Freedom Forever
Planset Revision Letter

2/14/2024
REV #1

Attn. County of Harnett (NC):

CATHERINE MEYER
332 DOCS ROAD , LILLINGTON, NC 27546

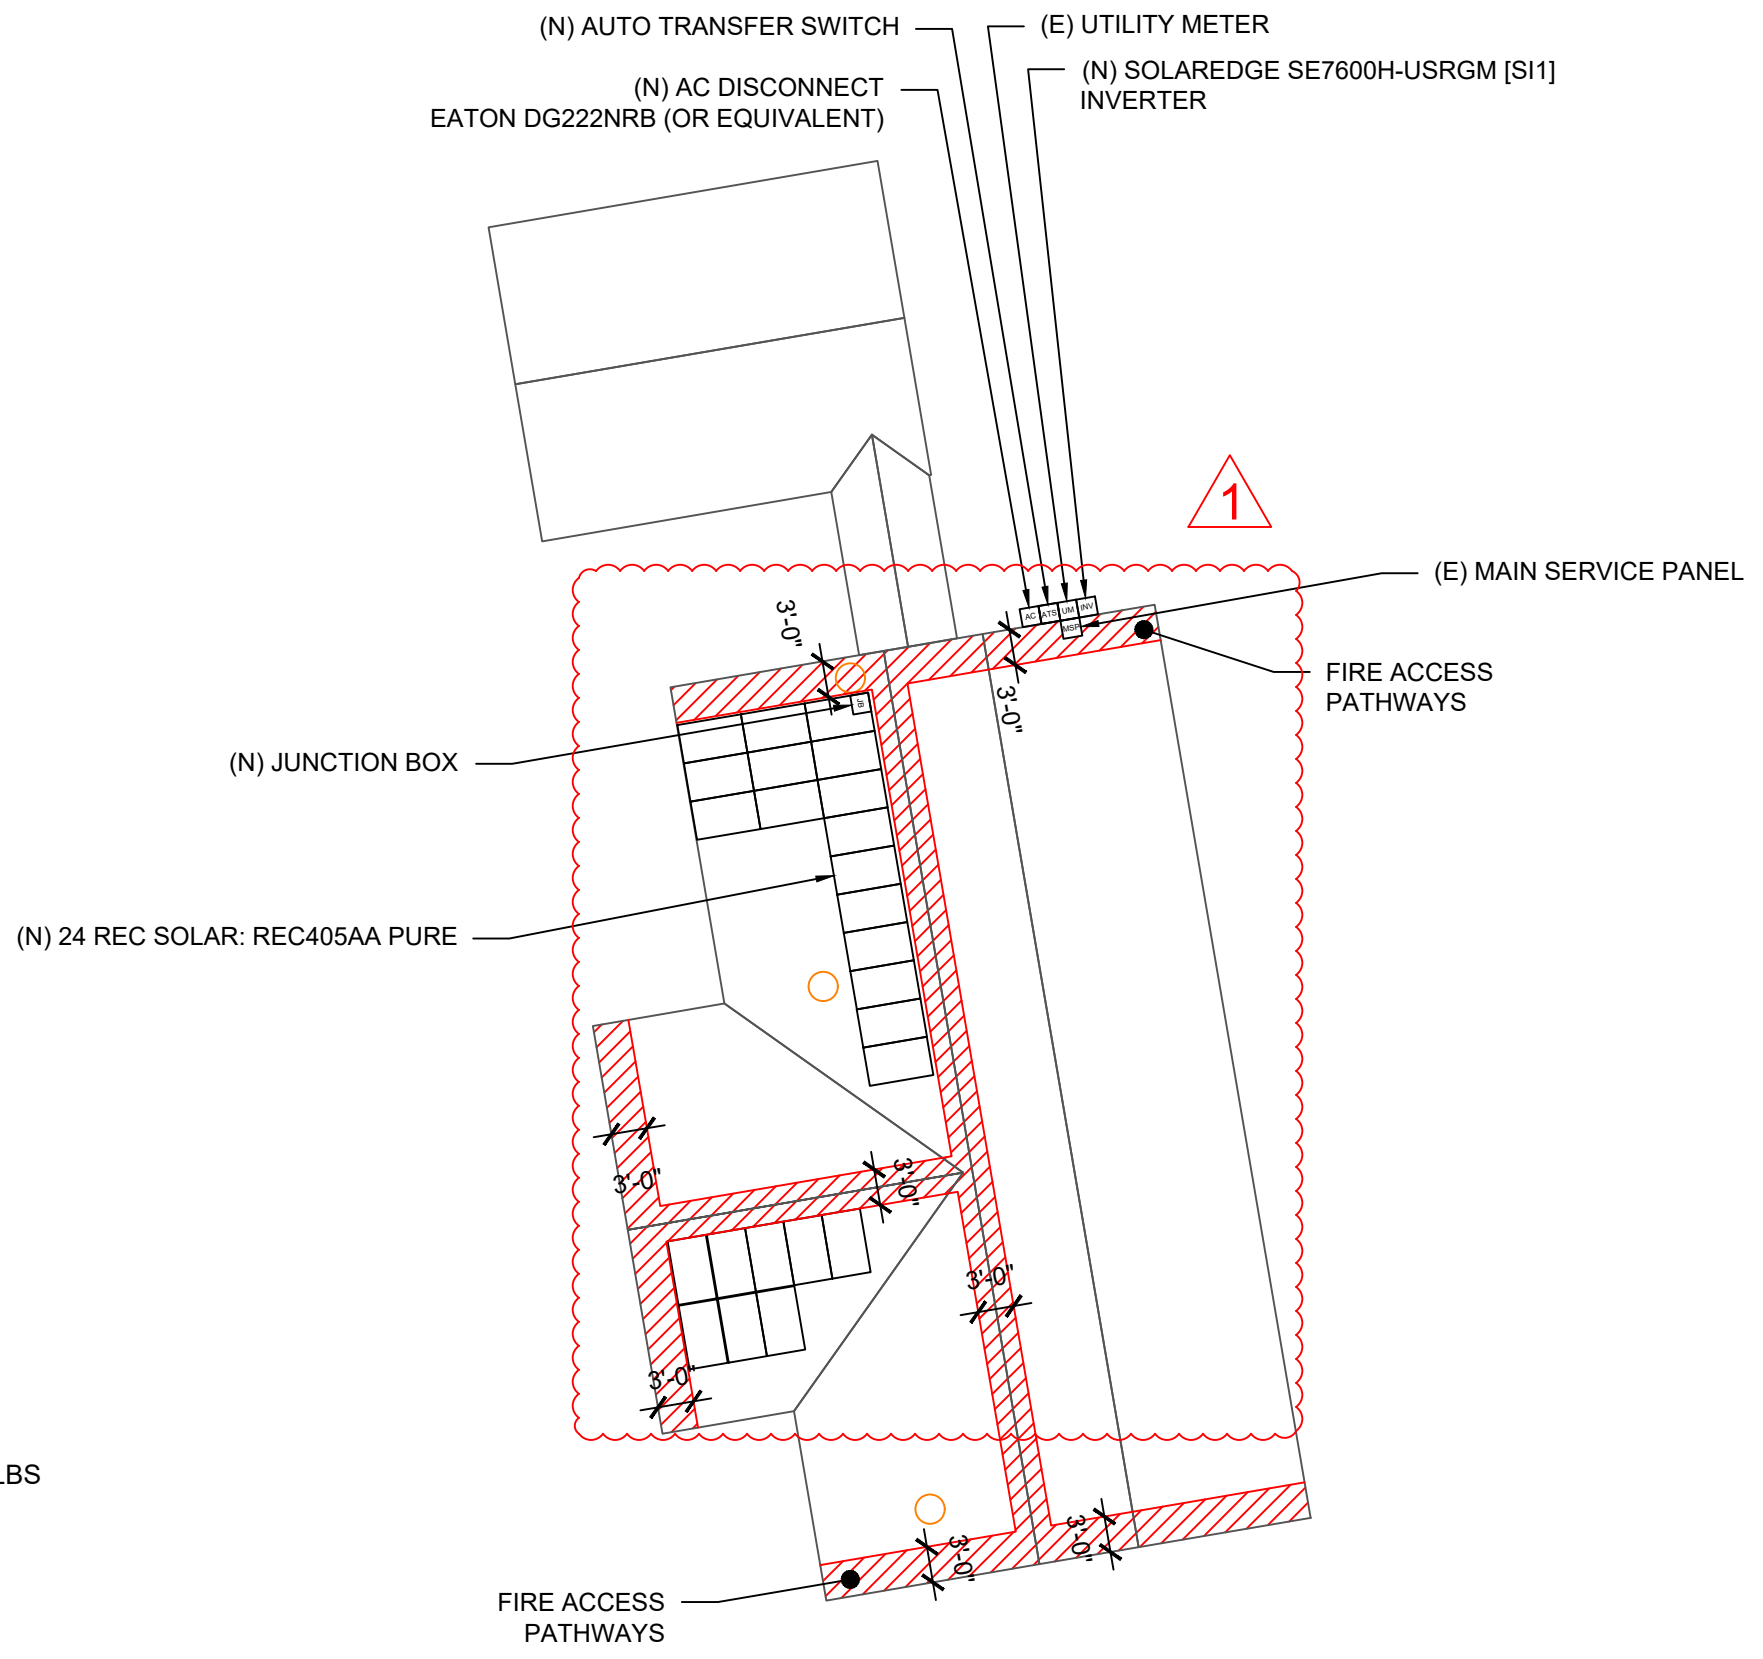
1. Layout updated
